REQUEST

Current Zoning: CC (commercial center)
Proposed Zoning: MUDD-O (mixed use development district, optional)

The petition proposes a residential development with up to 604 multi-family dwelling units in two development areas at Northlake Mall.

PLANNING STAFF REVIEW

RZ-1.0

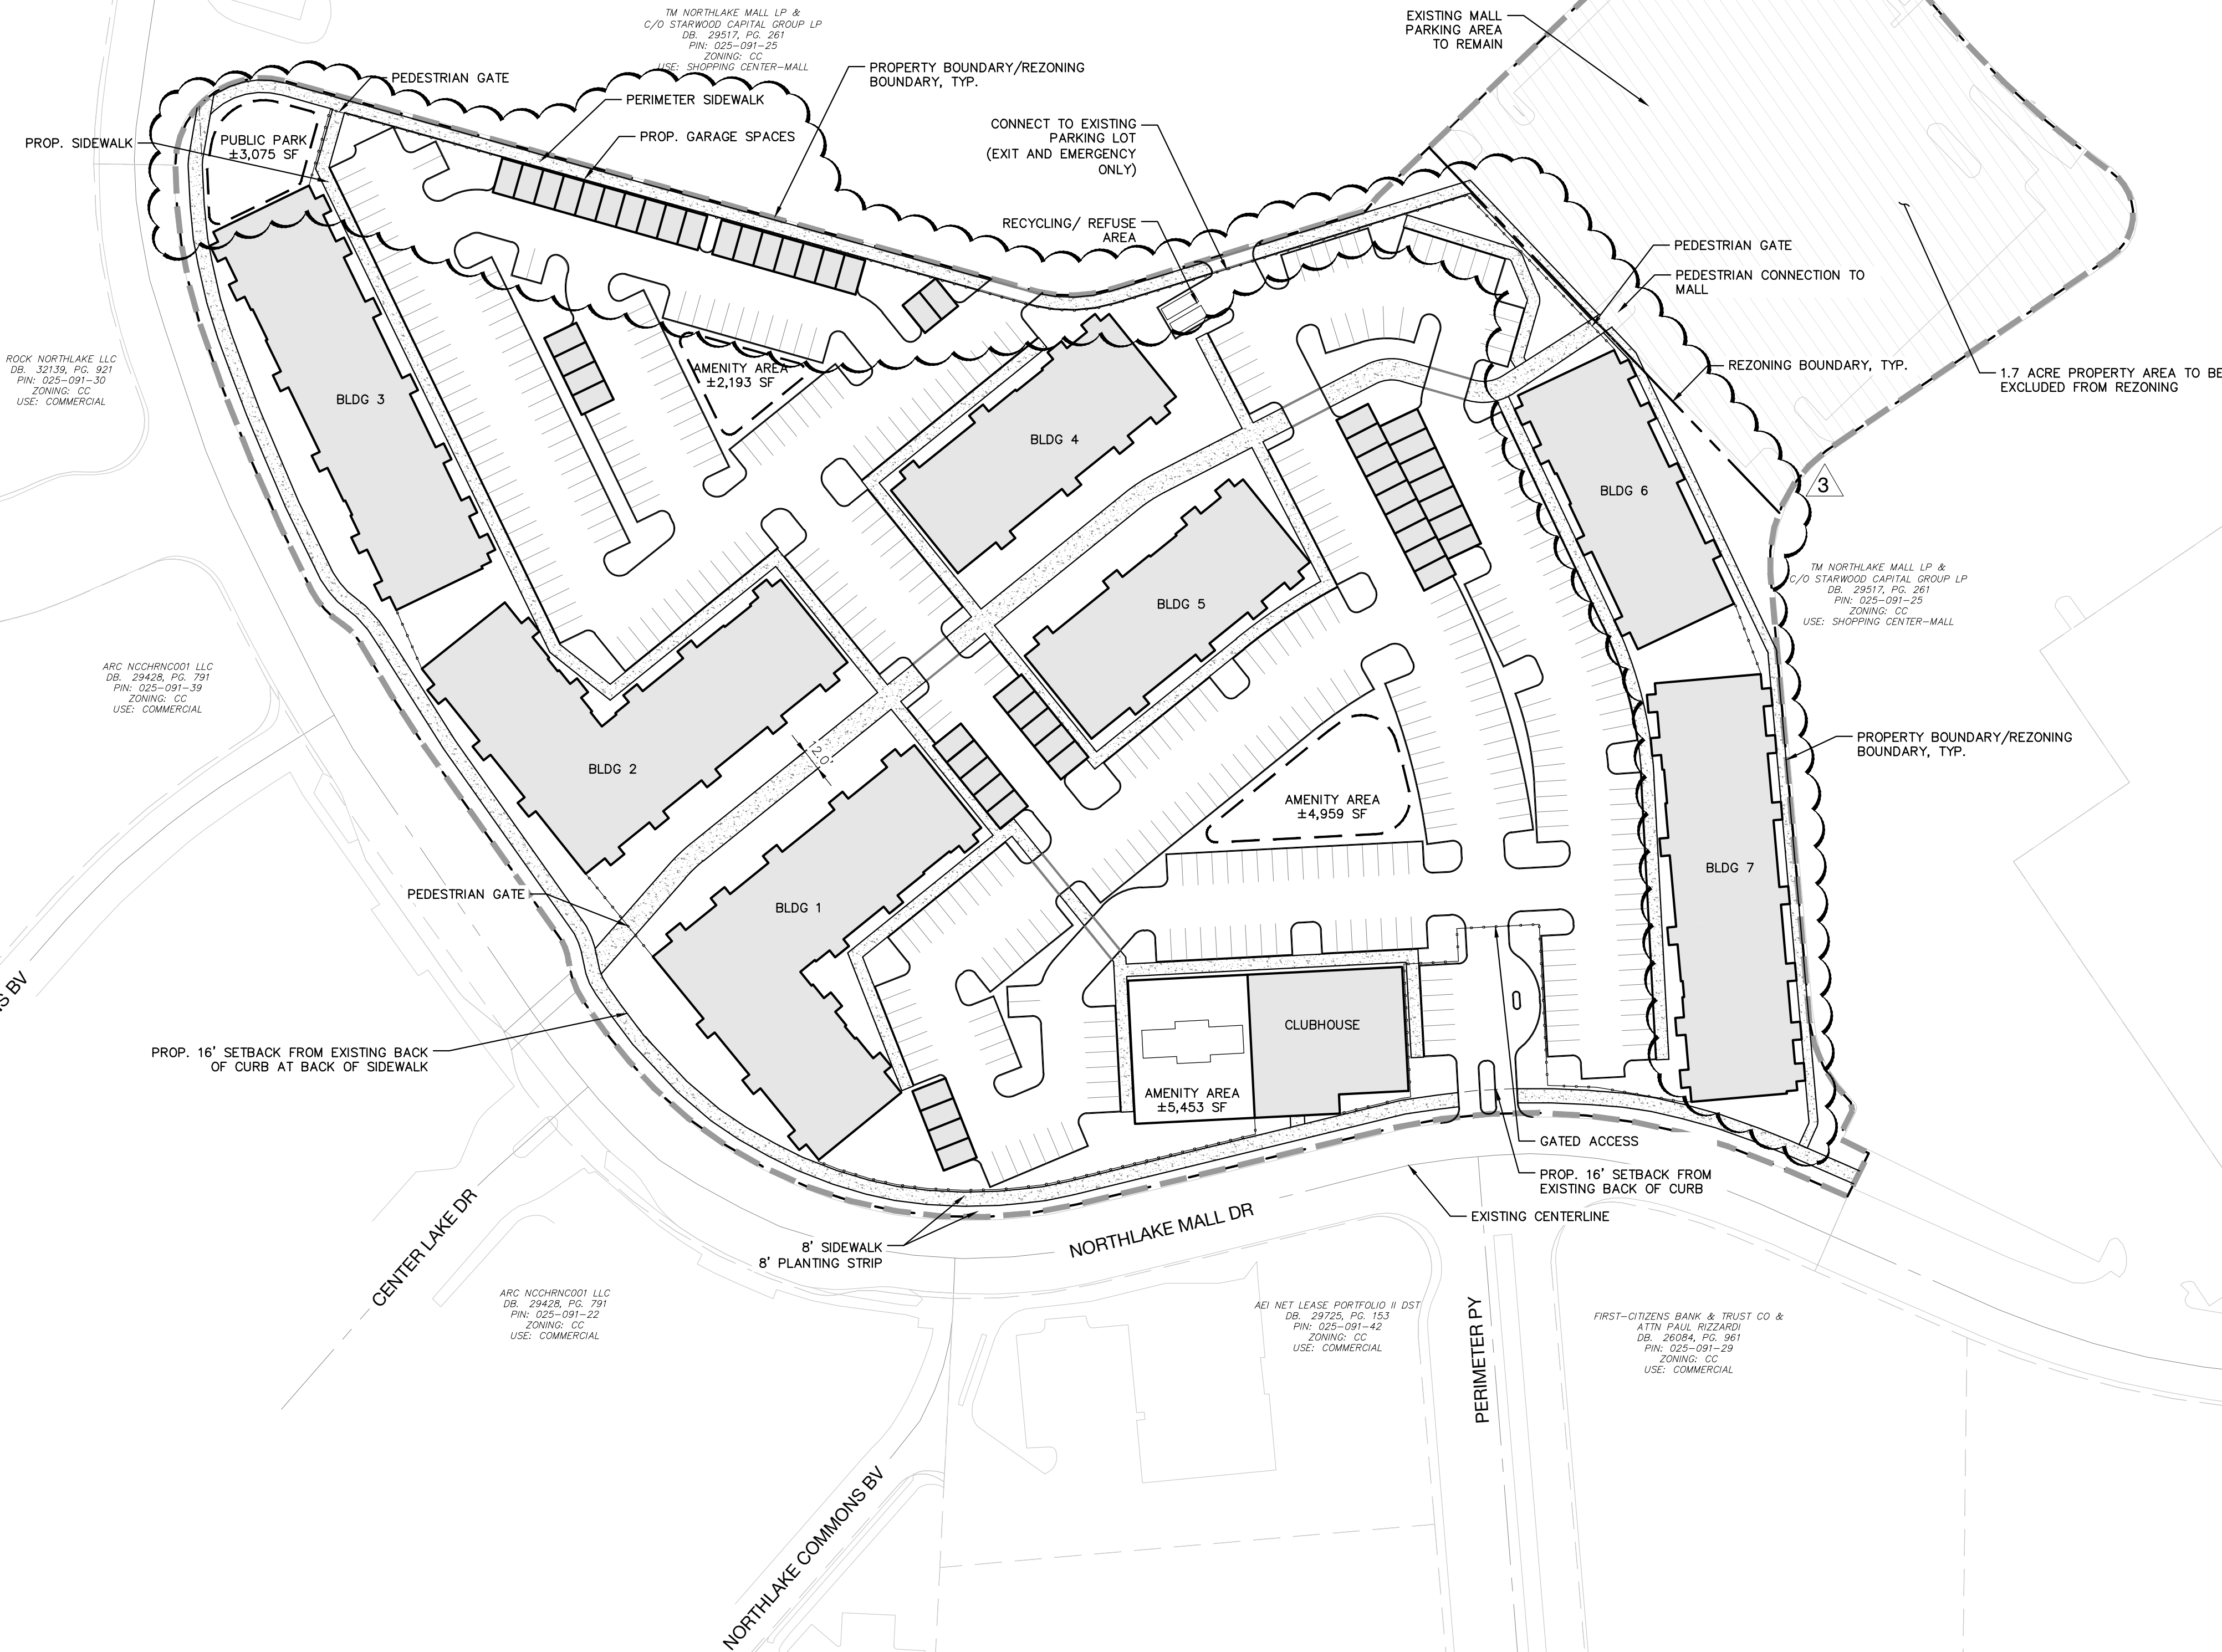
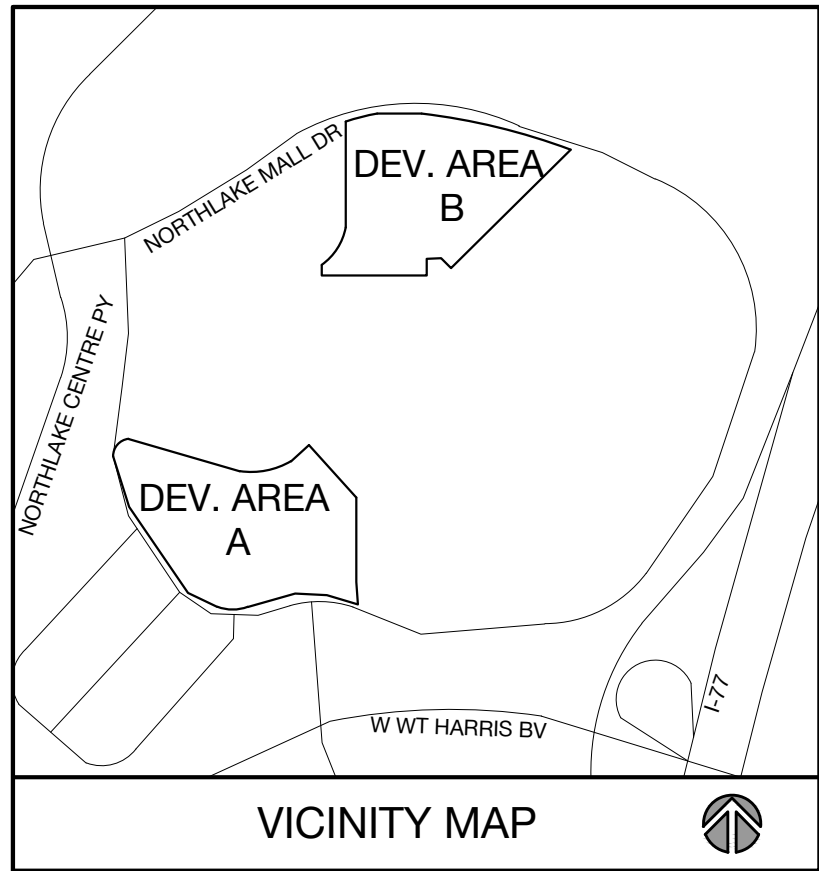
3. Remove perimeter fence and pedestrian gates.
4. ~~Continue sidewalk around the perimeter of the site of development area A.~~ Addressed
5. Clarify normal business hours at gated access points. Addressed
